**A1 Birtley to Coal House**  
**Scheme Number: TR010031**  
**Applicant's Response to Deadline 5**

**Applicant's Response to Deadline 5 Submissions**

<b>Version</b>	<b>Date</b>	<b>Status of Version</b>
Rev 0	19 May 2020	For Issue

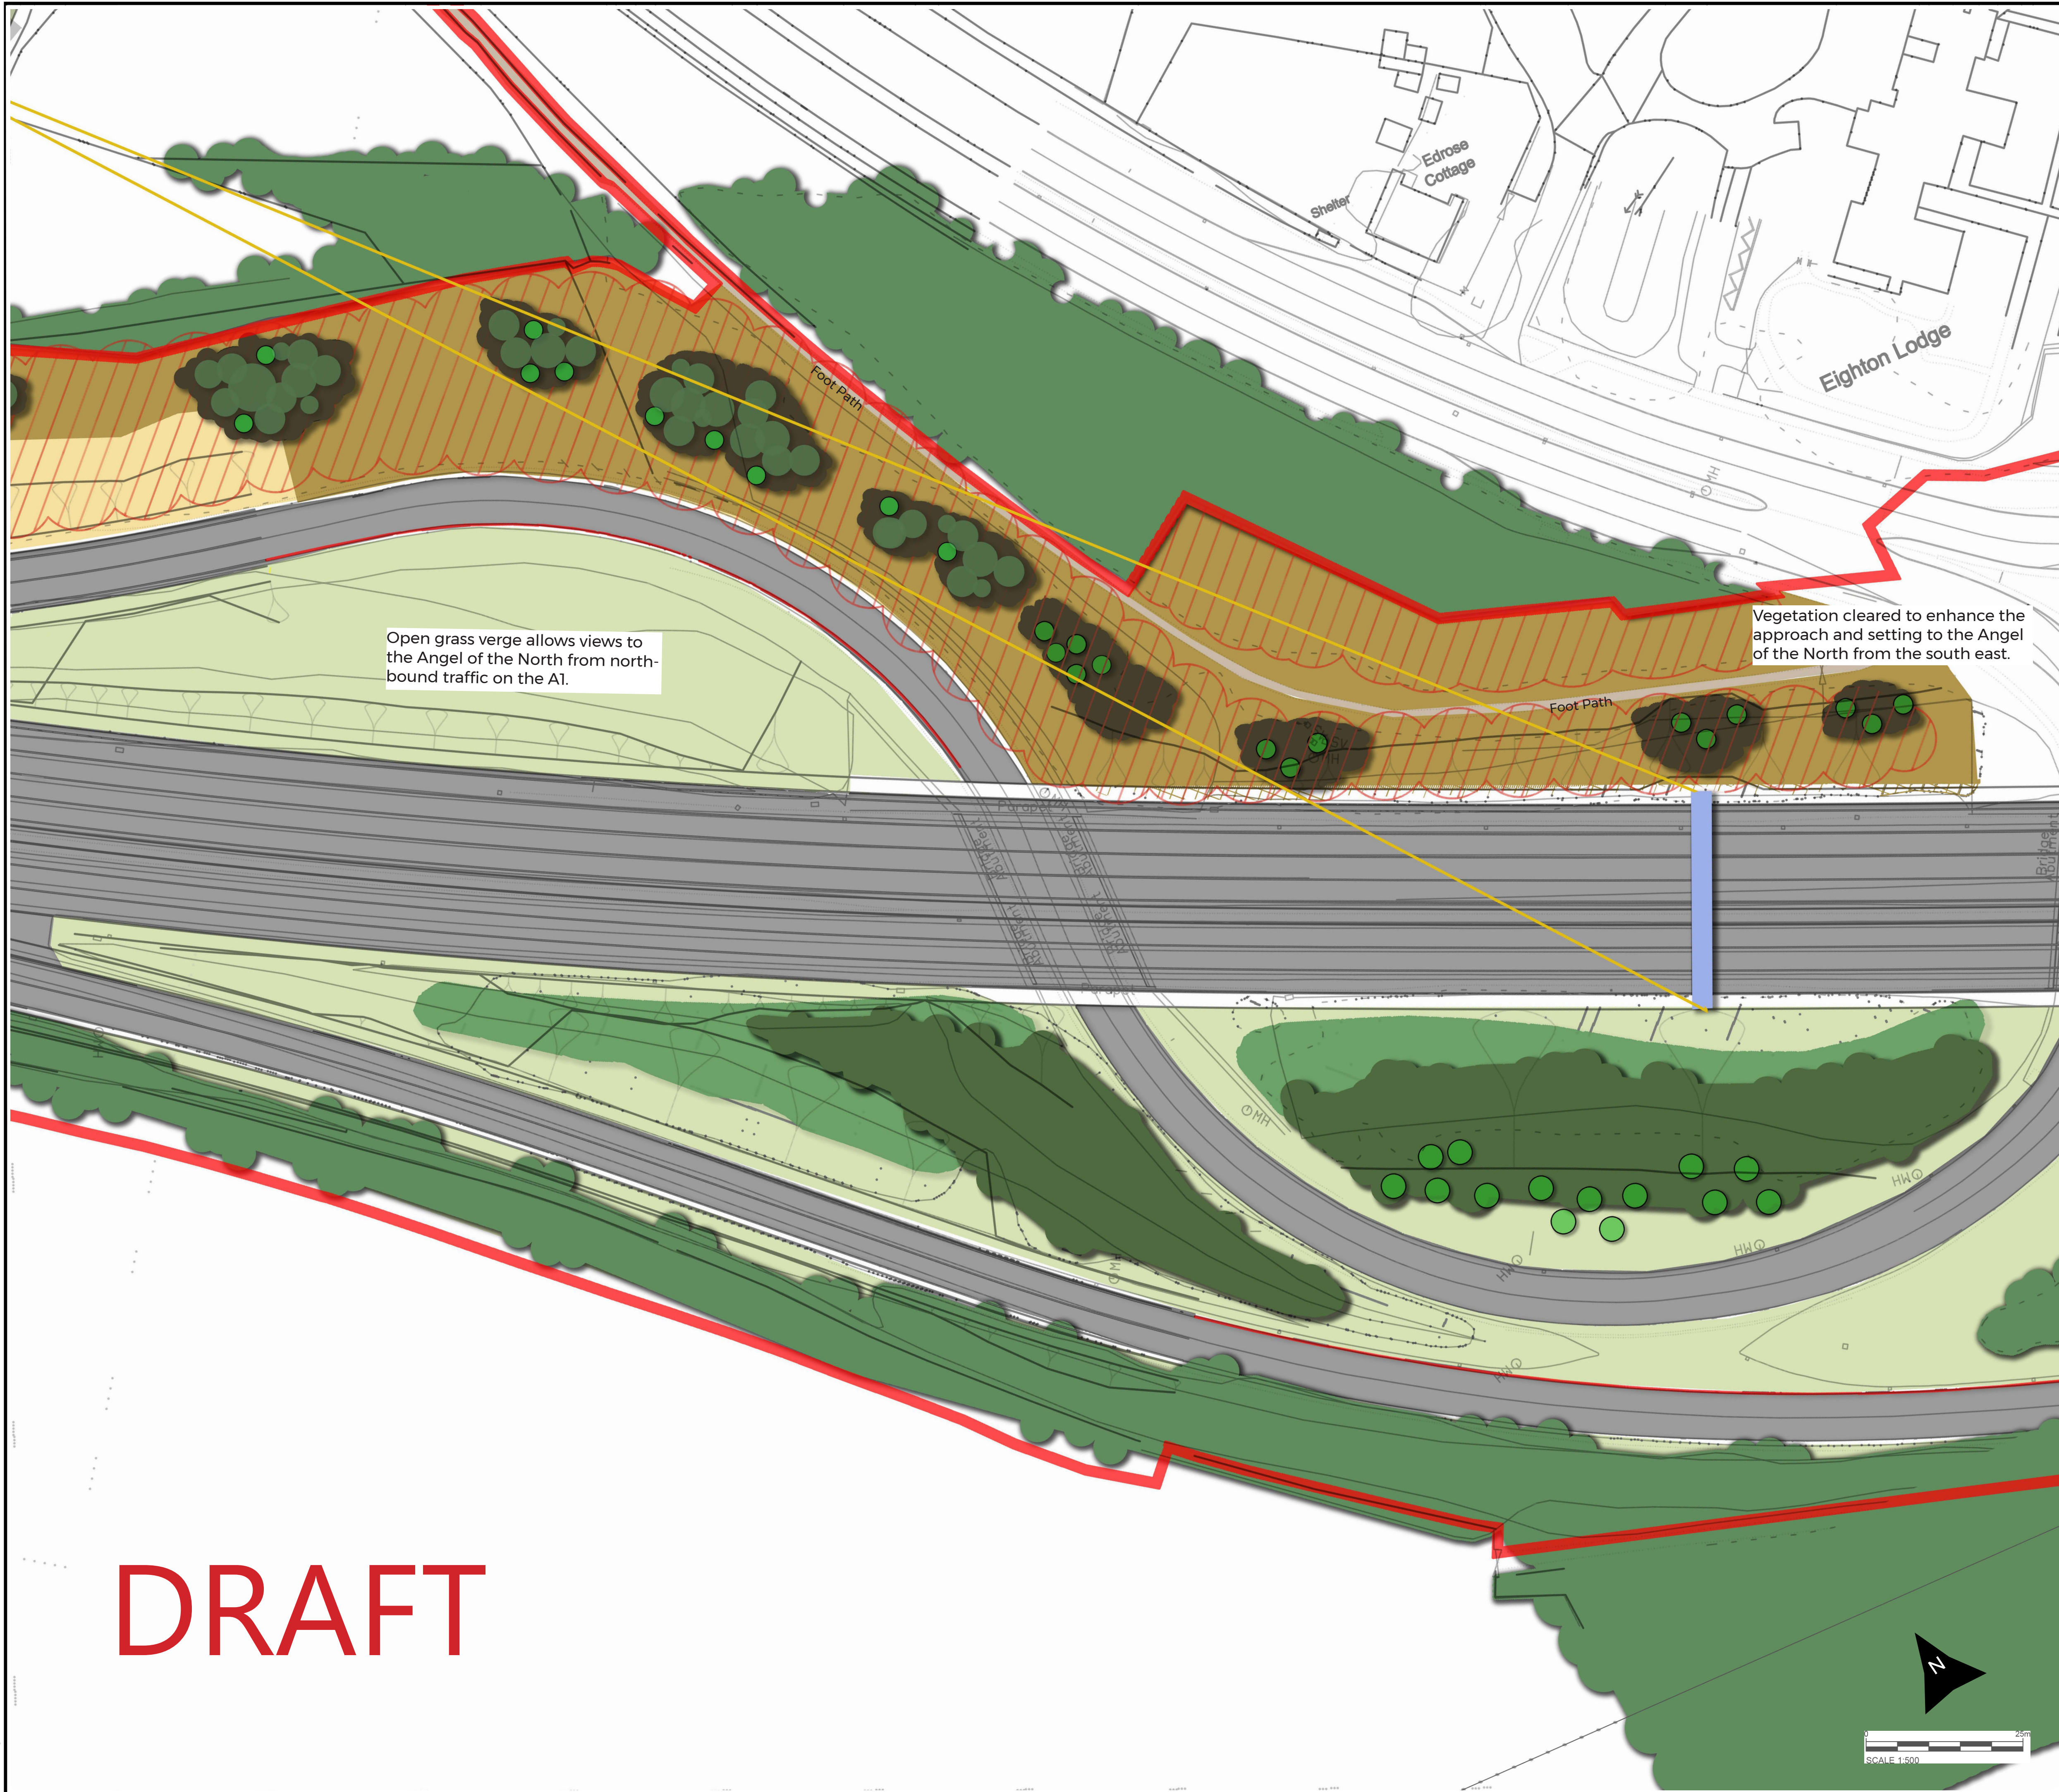
<p>4.4.8.b</p>	<p>We understand that the Applicant is currently in conversation with Gateshead Council regarding landscape mitigation plans and vegetation management schemes and welcome a coordinated approach. We would be grateful for any updates on these discussions, and further assurances that the opening up of views to the Angel of the North to minimise the negative effect of gantry placement will be prioritised in these plans</p>	<p>In so far as possible (and without compromising other mitigation required for the Scheme as a result of effects upon biodiversity, etc.), the Applicant continues to seek a design that can accommodate the aspirations of Gateshead Council in respect of the setting of the Angel of the North. However, this is not necessary to mitigate the impacts of the Scheme.</p> <p>The Applicant would draw the ExA's attention to the Applicant's Responses to ExA's Second Written Questions, Appendix 2.5A - Angel of the North Sketch Proposal (Rev 0) [REP4-044], that demonstrates the development of the mitigation design in respect of the proposals associated with the Angel of the North, which are subject to ongoing discussions with Gateshead Council.</p> <p>The revised design currently being discussed between Highways England and Gateshead Council, as an adaption to the mitigation as set out in Figure 7.6: Landscape Mitigation Design [APP-061], proposes to retain some existing trees and plant replacement trees in small clumps in order to ensure that views of the proposed gantries at chainage 12450 and 12870 have an appropriate level of screening in views from the Angel of the North, and that the findings of the assessment as set out in Chapter 7: Landscape and visual [APP-028] of the ES are unchanged. As the revised design is not yet agreed, this has not</p>

5.2.4 – The Applicant's response to Gateshead Council's Local Impact Report		
5.2.4.a	<p>All visual assessments carried out by the Applicant to date do not factor in the proposed Southern Green Landscaping plan developed by Gateshead Council. This plan aims to reveal more views to the Angel of the North and to manage the now overgrown vegetation that currently surrounds the Artwork.</p>	<p>The Scheme is designed to fit in the environment that was assessed at the time of the application. An application for development consent is not required to take account of unknown or speculative future scenarios.</p> <p>The Southern Green Landscaping Plan (appended to REP4-063) was not available to the Applicant at a time that enabled it to inform the visual assessments presented in Chapter 7: Landscape and Visual [APP-028] of the ES. It has only recently been made available to the Applicant by Gateshead Council, and has not been formally published. Also, the Southern Green Landscaping Plan is not adopted planning policy or an initiative that is actually being implemented.</p> <p>As previously stated in response to 5.2.1a above, and the Applicant's Response to Deadline 4 Submissions [REP5-010] Table 1, 2.0.7 a), b) and c), the position of the Applicant remains that the Scheme has been assessed against the existing baseline, which includes the presence of the existing tree coverage, and includes measures to mitigate its effects in its existing landscape. These measures are currently outlined in Figure 7.6: Landscape Mitigation Design [APP-061].</p> <p>It is against industry recognised assessment guidance to assess a development against a different baseline unless there is sufficient certainty that it will occur, which is not the case here in relation to the resumption of previous levels of vegetation or the implementation of a remodeled setting that is yet to be committed.</p> <p>However, so far as possible (and without compromising other mitigation required for the Scheme as a result of effects upon biodiversity, etc.), the Applicant is continuing to discuss with Gateshead Council a design that can accommodate its aspirations, as set out in the</p>

5.2.4.b	<p>The conclusions drawn in the Applicant's reports fail to reflect the significant disruption that would be caused by the proposed gantries. The Applicant consistently diminishes the impact of the gantries by referring to current vegetation cover. This is not a representative assessment of the true potential impact. The Southern Green 'Revealing the Angel' scheme embodies our desire, and Gateshead Council's desire, to effectively manage the surrounding vegetation to maximise views of the Angel of the North. The current state of the vegetation is not as intended.</p>	<p>As stated above in response to 5.2.4.a, the Southern Green Landscaping Plan (appended to REP4-063) was not made available to the Applicant in order for it to inform the visual assessments presented in Chapter 7: Landscape and Visual [APP-028] of the ES. It has only recently been made available to the Applicant by Gateshead Council, and has not been formally published. It is not a requirement to address an aspiration or an intention expressed in an unpublished document of which the Applicant was not aware at the point of application.</p> <p>The Applicant disagrees with the suggestion that the proposed gantries would result in significant disruption. As demonstrated in the Applicant's Responses to ExA's First Written Questions, Appendix 1.5A, Angel of the North Narrative [REP2-019], and the Applicant's Comments on Local Impact Report [REP3-005], Appendix 5.2 – North Dene Photomontage, views of the Angel of the North are frequently obscured by existing mature woodland and trees within the wider landscape. The Applicant has consistently acknowledged that the proposed gantries would intermittently disrupt transitory views, but that the impact would be of very short duration and would ultimately not result in a significant effect.</p> <p>Whilst the current level of surrounding vegetation may not be as intended (but presumably was understood since the land is managed by Gateshead Council), it is against industry recognised assessment guidance – and would be unreasonable - to assess a development against a different baseline unless there is sufficient certainty that it will occur, which is not the case here in relation to the resumption of previous levels of vegetation or the implementation of a remodeled setting that is yet to be committed. As stated above in response to 5.4.2a, the Applicant is continuing discussions with Gateshead Council on the incorporation of the vision, as set out in the Southern Green Landscaping Plan (appended to REP4-063), and wishes to draw the ExA's attention to the Applicant's Responses to ExA's Second Written Questions, Appendix 2.5A - Angel of the North Sketch Proposal [REP4-044], that demonstrates the development of the mitigation design in respect of the proposals associated with the Angel of the North, which are subject to ongoing discussions with Gateshead Council. Agreement on the final landscape design will be referenced in future updates to the Outline CEMP [REP4-022 and 023] and subsequent iterations of the Statement of Common Ground with Gateshead Council (latest version submitted at Deadline 4 [REP4-024]).</p>

<p>design of the landscape strategy set out in Figure 7.6: Landscape Mitigation Design [APP-061] can be adapted and developed so as to contribute towards the delivery of the vision for the site (refer to Applicant's Responses to ExA's Second Written Questions - Appendix 2.5A, Angel of the North Sketch Proposal [REP4-044]).</p> <p>The Applicant considers that the mitigation it is taking is appropriate in the circumstances.</p>
<p>4.4.8 – The Applicant's response to Gateshead Council's Local Impact Report</p>		
<p>4.4.8.a</p>	<p>We would like to reinforce the issues raised in Gateshead Council's Local Impact Report, and would like more guarantees from the Applicant that, as proposed in Figure 7.6: Landscape Mitigation Design [APP-061], any reduction in views to the Angel of the North are considered and compensated for in the landscape design and mitigation planning. For example, the Applicant has suggested that woodland edge planting between chainage 12300 – 12560 could be less dense to allow greater potential for views to the Angel of the North, but we propose that there are no trees in this area at all, in line with Gateshead Council's commitment to opening up the site to its original configuration.</p>	<p>The current status of the planting between chainage 12300 and 12560 is woodland edge planting and scattered trees, to replace the vegetation that would be removed by the reprofiling of the existing cutting slope. It is necessary for the Scheme to mitigate its effects on the existing environment within its control. The removal of further planting includes dealing with vegetation outside the Order limits, which is not in the Applicant's control. If additional planting is proposed to be removed, then the ecological consequences of this have to be addressed by Gateshead Council, as this is not a consequence of the Scheme.</p> <p>As stated above, the Applicant is continuing discussions with Gateshead Council on how the design of the landscape strategy set out in Figure 7.6: Landscape Mitigation Design [APP-061] can be adapted and developed so as to contribute towards the delivery of the vision for the site (refer to Applicant's Responses to ExA's Second Written Questions, Appendix 2.5A - Angel of the North Sketch Proposal [REP4-044]).</p> <p>Agreement on the final landscape design will be referenced in future updates to the Outline CEMP [REP4-022 and 023] and subsequent iterations of the Statement of Common Ground with Gateshead Council (latest version submitted at Deadline 4 [REP4-024]).</p>

<p>Southern Green Landscaping Plan (appended to REP4-063), in respect of the setting of the Angel of the North, reducing the extent to which vegetation currently screens views towards the artwork.</p> <p>The Applicant would therefore draw the ExA's attention to the Applicant's Responses to ExA's Second Written Questions, Appendix 2.5A, Angel of the North Sketch Proposal [REP4-044], that demonstrates the development of the mitigation design in respect of the proposals associated with the Angel of the North, which are subject to ongoing discussions with Gateshead Council. Agreement on the final landscape design will be referenced in future updates to the Outline CEMP [REP4-022 and 023] and subsequent iterations of the Statement of Common Ground with Gateshead Council (latest version submitted at Deadline 4 [REP4-024]). However, this is not necessary for the purpose of determining the application for a DCO.</p>
